Developer Services
Southern Water
Sparrowgrove House
Sparrowgrove
Otterbourne
Hampshire
SO21 2SW

PLAN-022912

31/05/2018

Proposal: Outline application with all matters for 6 No detached houses with detached garages. This application is a Departure from the Development Plan. Site: Former Lanes End House, Adjacent to West Walberton Lane & Arundel Lane, Walberton, BN18 0QS. WA/26/18/OUT

Former Lanes End - Six Six bedroom detached Houses with Garages Proposed Layout Scale 1:100 @ A3 (c) PJ Developments LTD 2018		REVISIONS		01
		MM/DD/YY	REMARKS	
	1	--/--/--	...	A
	2	--/--/--	...	
	3	--/--/--	...	
	4	--/--/--	...	
	5	--/--/--	...	
West Walberton Lane Proposal

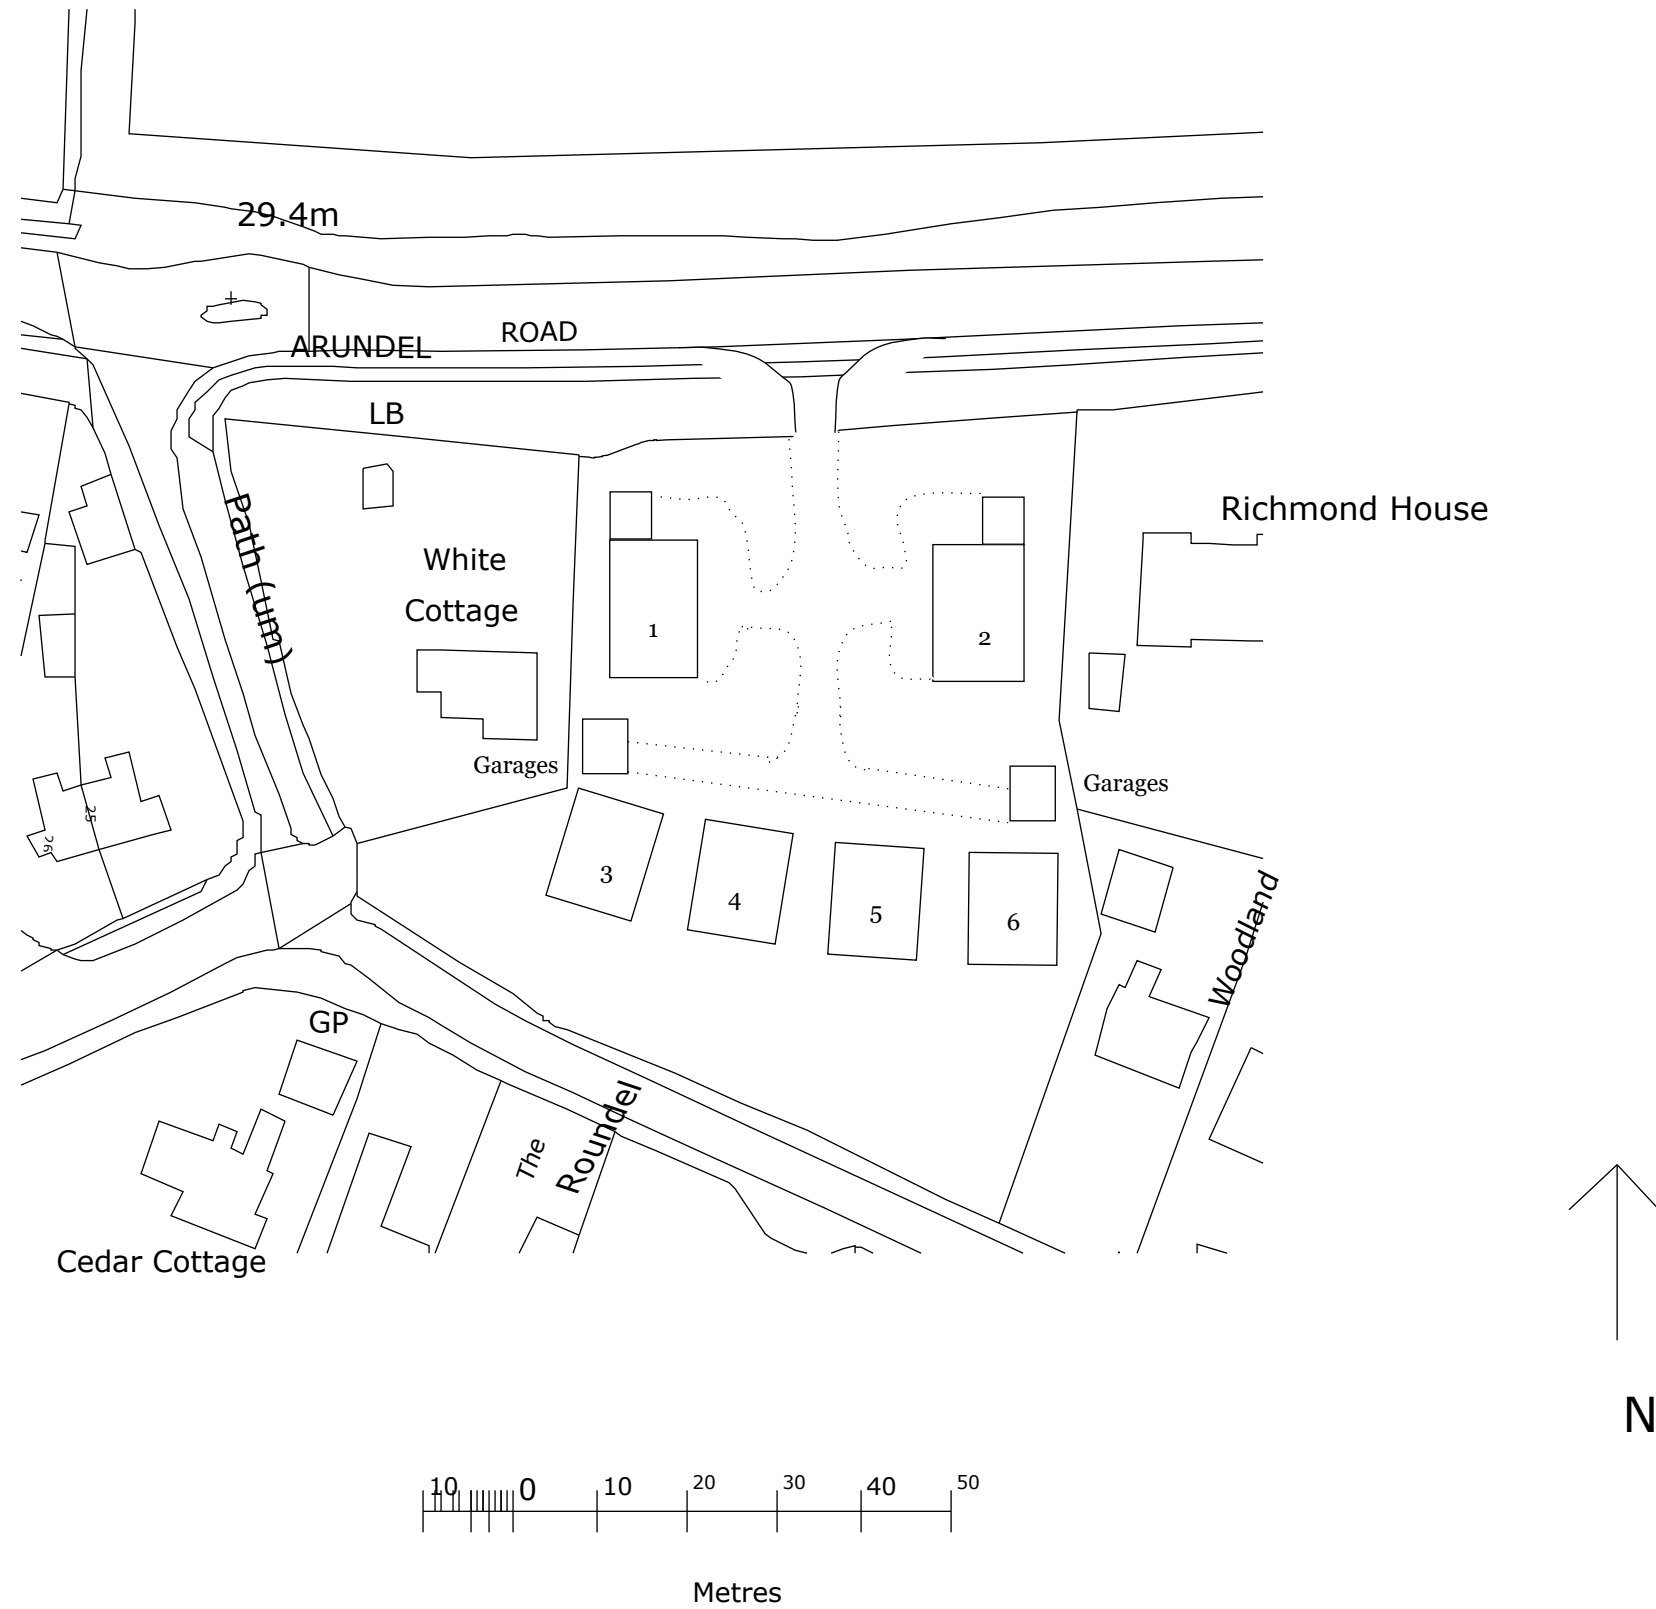
Please find attached a plan of the sewer records showing the approximate position of foul sewer crossing the site. The exact position of the foul sewers must be determined on site by the applicant before the layout of the proposed development is finalised.

1. The 150 mm diameter sewer requires a clearance of 3 metres either side of the sewer to protect it from construction works and allow for future access for maintenance.
2. No development or new tree planting should be located within 3 metres either side of the external edge of the public sewer
3. No new soakaways should be located within 5 metres of a public sewer.

Alternatively, the applicant may wish to amend the site layout, or combine a diversion with amendment of the site layout. If the applicant would prefer to advance these options, items (1) – (4) above also apply.
